City of Albuquerque Stormwater Construction Site Inspection Report

ESC File No.	M09E035	Project Name:	Take 5 Car Wash Snow Vista
NPDES Id. No.	NMIR1005E4	Location:	98th & Sage
1/24/2025	Owner	Contractor	
Operator	Boing US Holdco, Inc.	Spinoff Construction	
Contact name & title	Jorge Primo Planta	Jimmy Gibson	
e-mail	jorge.planta@drivenbrands.com		
Contact Phone #	919-699-7198	832-654-8008	
COA Inspector	Chancellor English	Start/End Time:	3PM
Construction Phase:	verticals		
Type of Inspection:	Regular	Storm Event	Post Storm Event >0.25"
		311/Complaint	Follow Up
Weather at time of inspection?	Clear	Temperature: ~	50
Estimated date of last storm 0.25" or greater	1/4/2024

DESIGN REVIEW COMMITTEE	CITY ENGINEER APPROVAL	ZONE MAP NO.
		Z-99
		CITY PROJECT NO. 000000
		SHEET NO. C-2.0

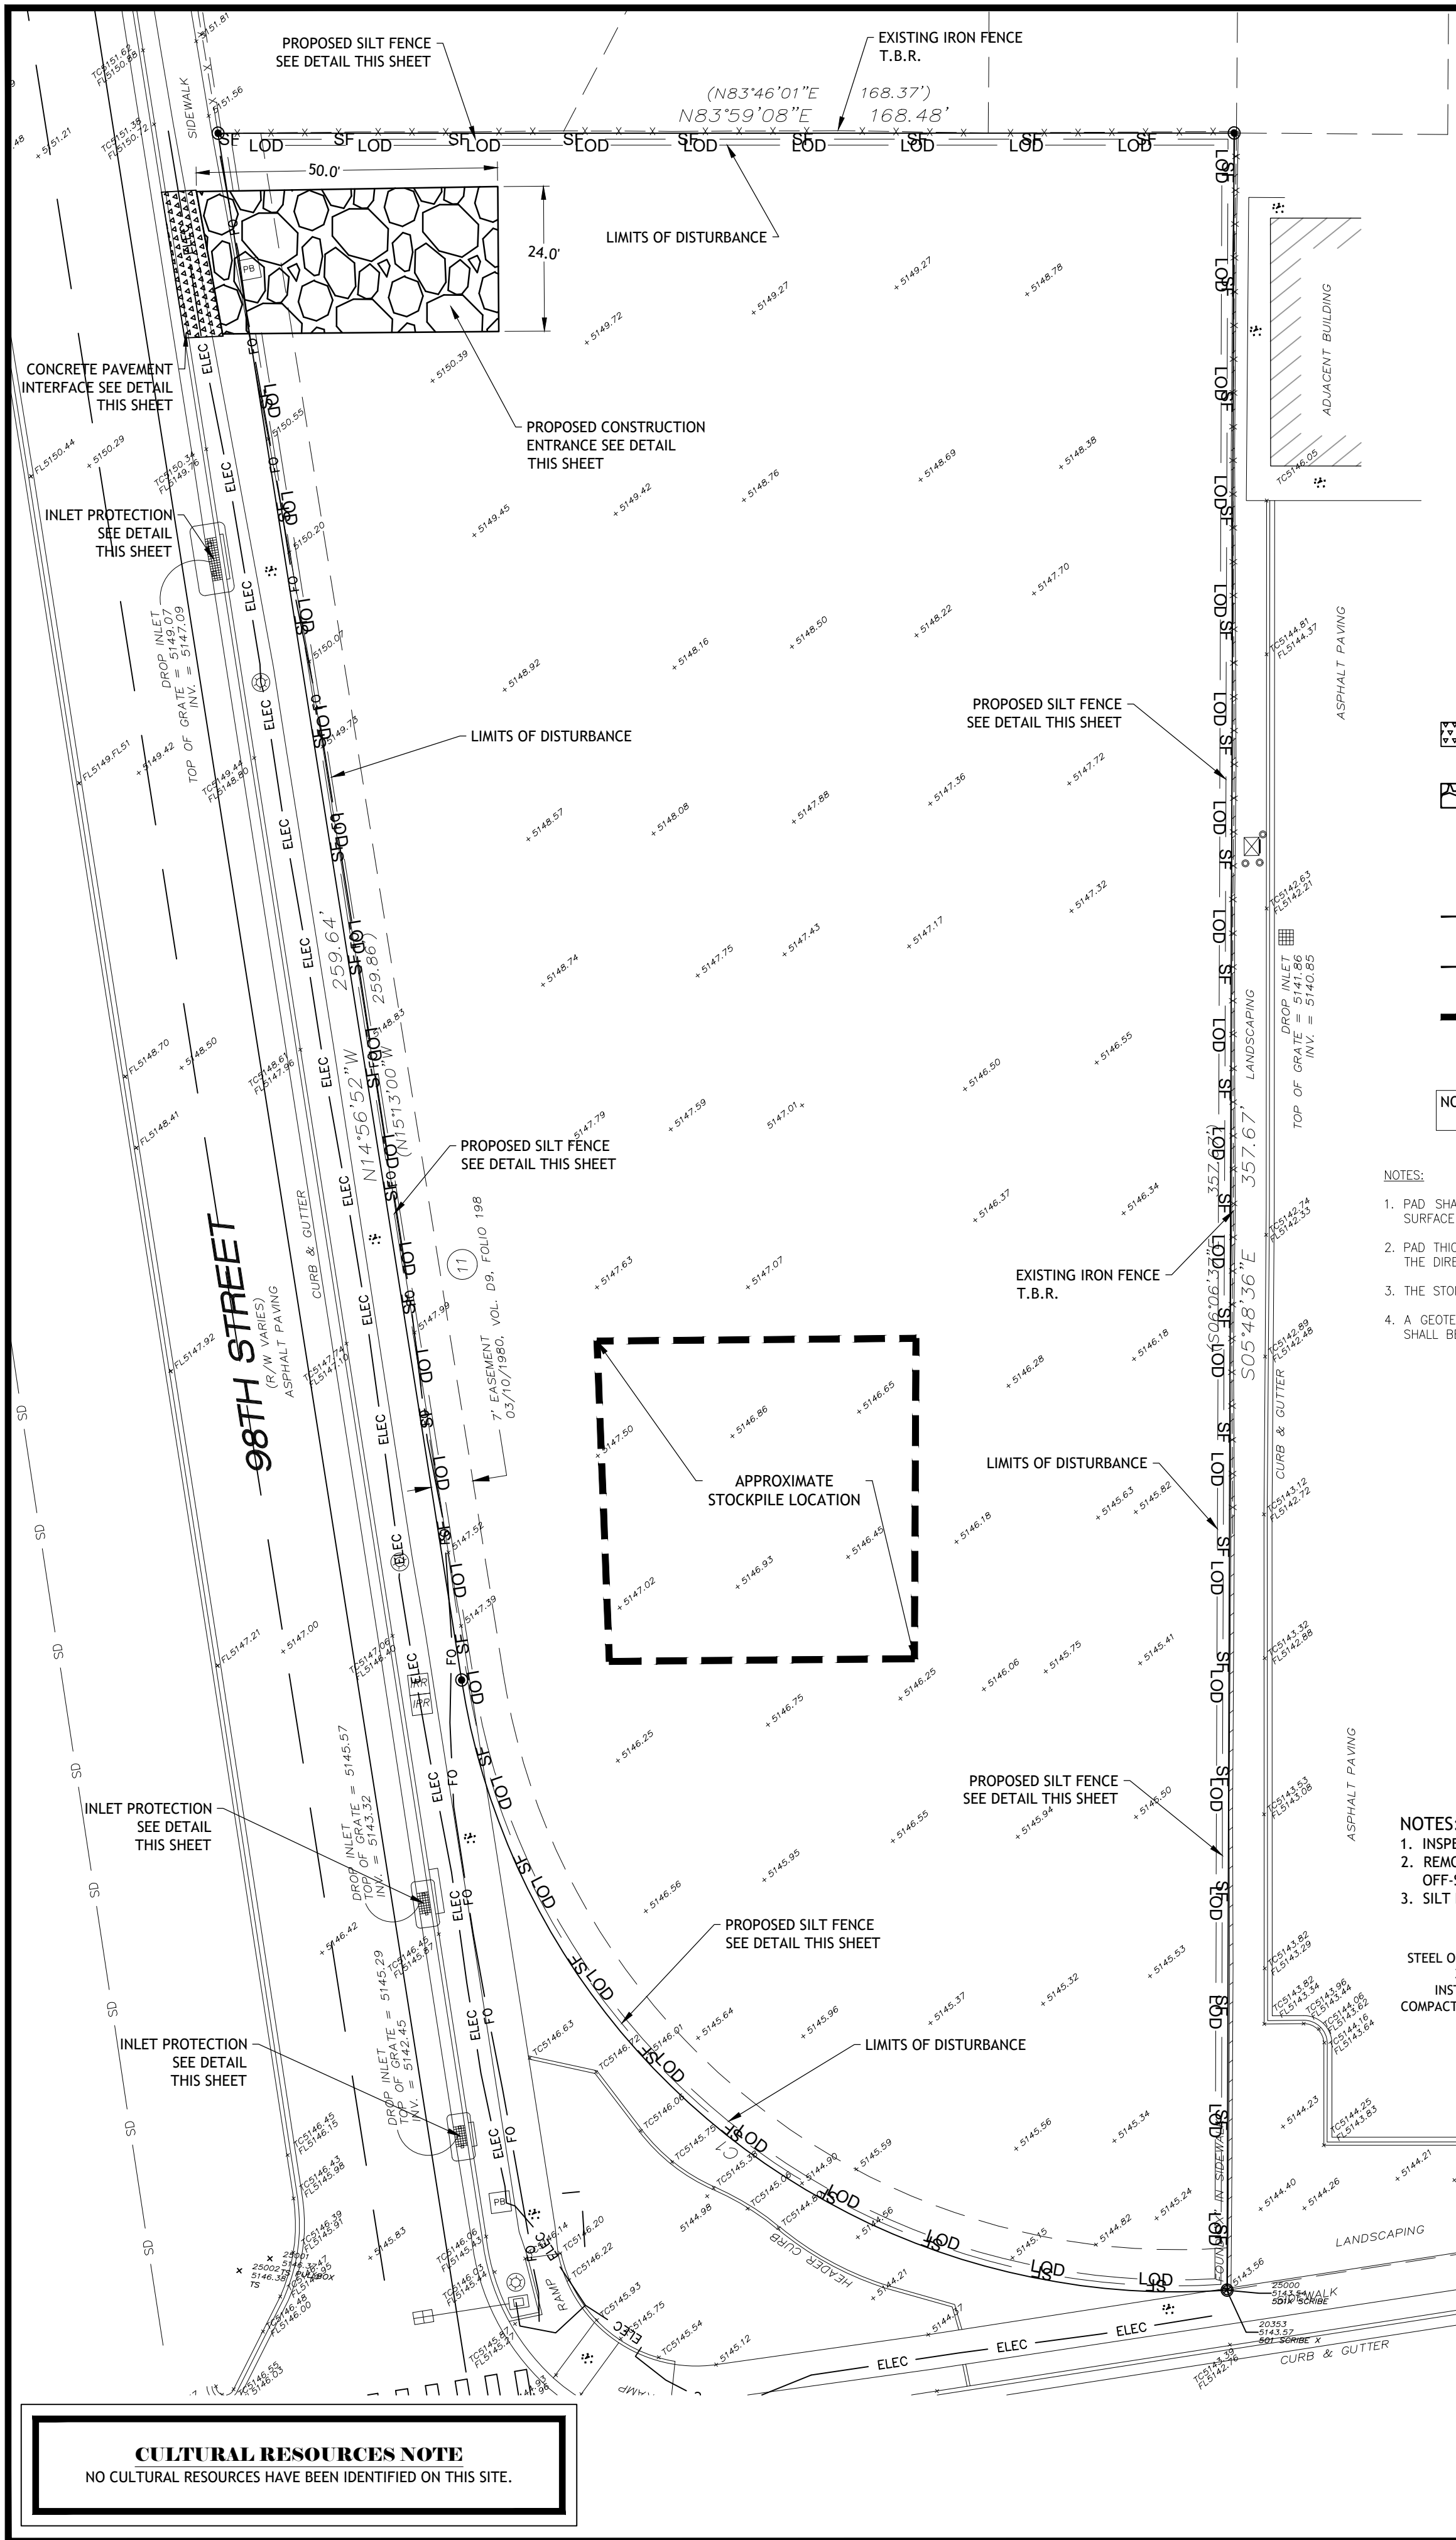
Item Number	Deficiency/ Corrective Action		
1	The SWPPP has not been certified by both operators' signatory in violation of CGP Part 7.2.10. The self-inspection reports were signed by the superintendent without a proper Delegations of Authority, and they were not signed by the owner in violation of CGP Part 4.7.2. Required Mitigation The SWPPP, including the SWPPP Map, Self-Inspection Reports, and Corrective Action Reports, must be kept up-to-date per CGP 7.1 and available on-site per CGP 4.7.3, 5.4.3 and 7.3. Your SWPPP, corrective action log, site inspection, and any other compliance documentation required under this permit, must be signed by the same responsible corporate officer that signs the certification statement on your NOI or by a duly authorized representative of that person per CGP Appendix G.11.2.		
2	The Construction Exit was full of sediment and needs reset.
